Planning Application Ref: R/198/20/T

Location: Various locations, Sea Estate, Rustington

Description of works: Various works to various trees

SEA ESTATE RUSTINGTON
PROPOSED WORK TO TREES WITH PRESERVATION ORDERS (TPO'S)
2020 - 2021
REFER TO APPLICATION TABLE A FOR SCOPE OF WORKS

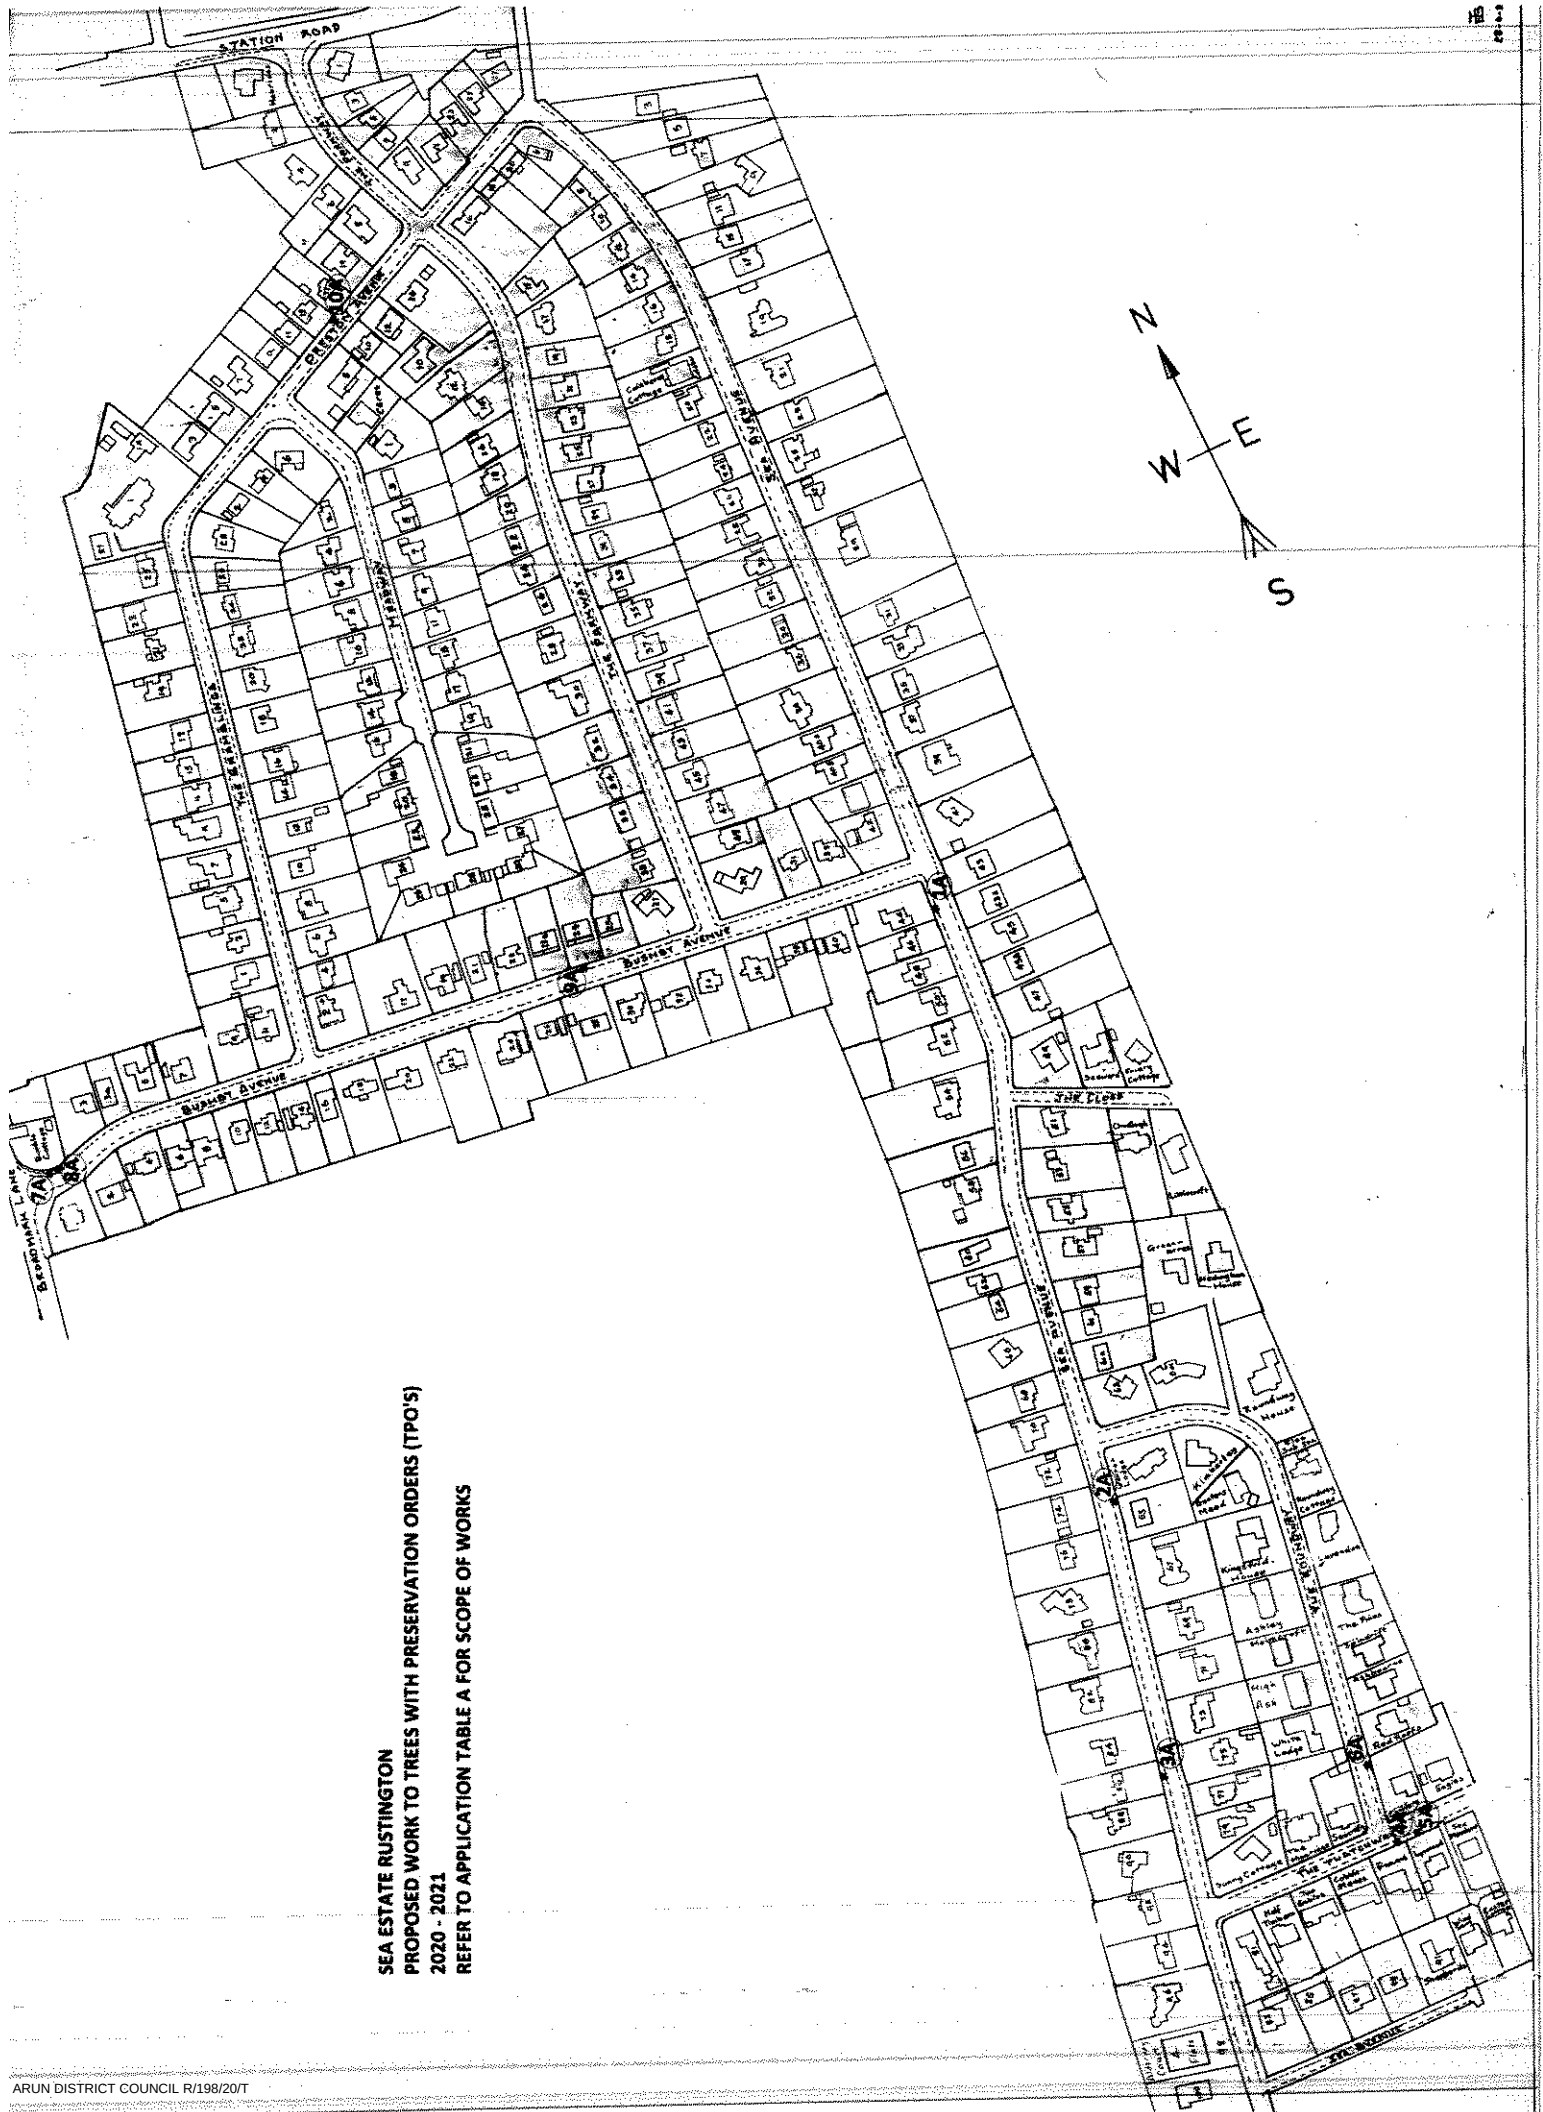
1A Black pine – The removal of two branches from this limb is not justified on arboricultural grounds. Such growth does not appear to be problematic or causing actionable nuisance. Pine of this age especially do not easily generate new growth to compensate for such loss and the progressive removal of healthy low branches diminishes their aesthetic value. **Recommend refusal.**

3A Scots pine – *Deadwood and tip back all branches on N & E side by 1m to rebalance tree.* Outwardly healthy tree with asymmetric form (wind sculpted). The removal of deadwood is an exception from the normal application process. Support in principle. **Amendment to work proposal (branch reduction) is required.** See advisory below for suggested description.

4A – 8A incl. 5x Monterey cypress – No arboricultural justification for crown reduction pruning. It is accepted that during inclement weather small branches may break and with so many large examples of evergreen tree on the estate, those cypress will inevitably present tree managers with a high maintenance requirement. Any benefit accrued in that respect following wholesale crown reduction is likely to be slight in my view and not sufficient to justify the loss of visual amenity and commitment to repeating those works on a cyclical basis. **Recommend refusal.**

10A Scots pine – *Reduce NE limb over drive by 1.5m back to live growth and remove secondary (lower) limb.* Unable to interpret with confidence from site. In any event, pine of this age especially do not easily generate new growth to compensate for such loss and the progressive removal of healthy low branches diminishes their aesthetic value. **Amendment to work proposal required.** See advisory below for suggested description.

- **Remove T1A and T4A - T8A from the proposal.** Note: The removal of deadwood is an exception from the normal application process.
- **3A.** New specification to read: *'Prune selected branches to achieve maximum 1.5m reduction of lateral crown spread on North and East aspects only.'*
- **10A.** New specification to read: *'Remove the one (lowest hanging) branch which is both pendulous and declining, leaving a final pruning cut of no larger than 75mm diameter.'*
